Addendum No. 1

RE: Contract # C204355

Watauga County (R-2566BA)

BRIDGE OVER WATAUGA RIVER AND LEFT TURN LANE AT SR-1112
(BROADSTONE RD) ON NC-105 WITHIN R-2566B LIMITS

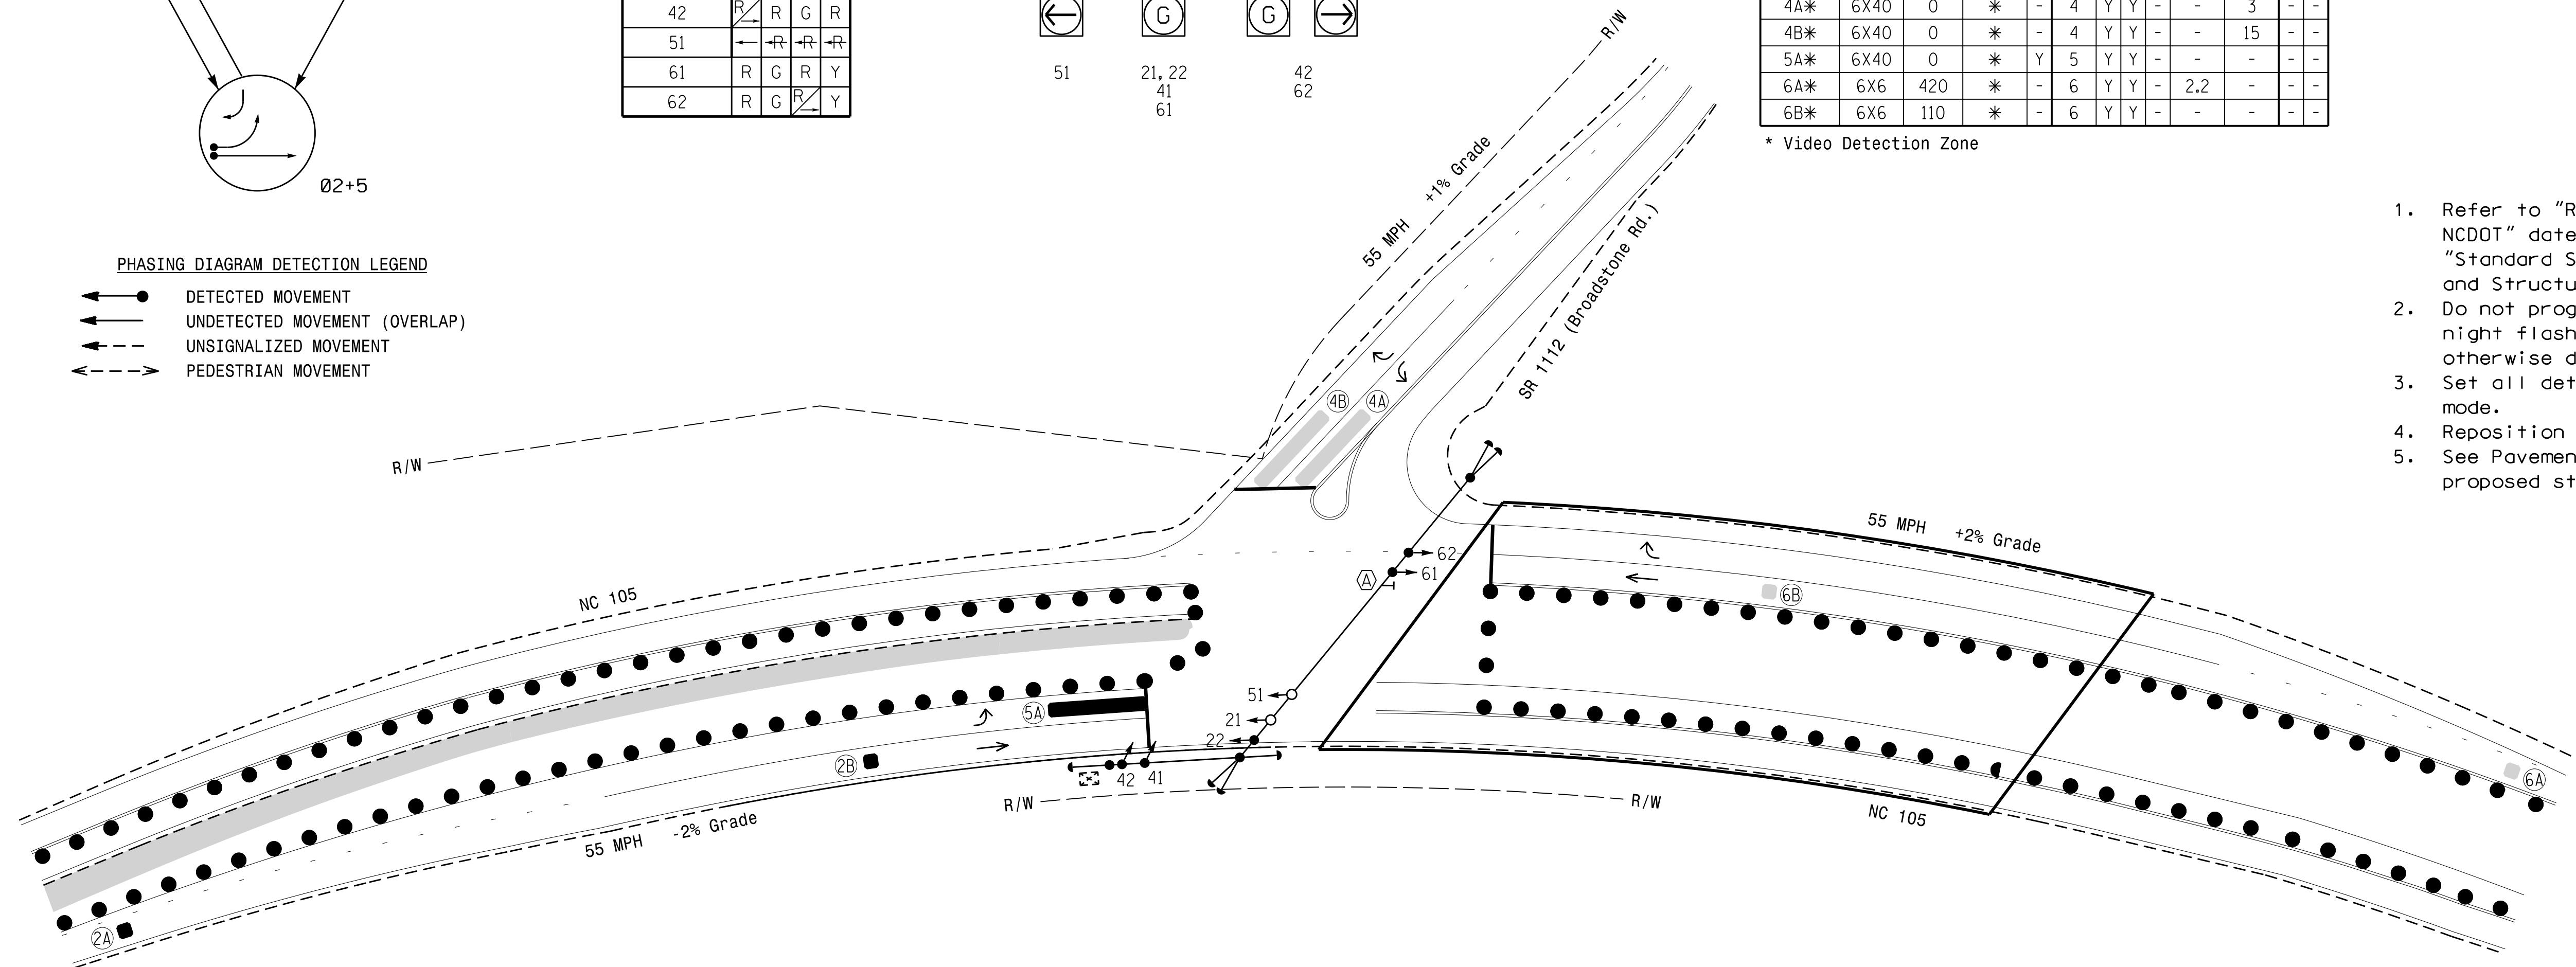
Sheet No.	Revision
Sig 7.0 and Sig 7.1	Revised to add metal pole case numbers for three strain poles
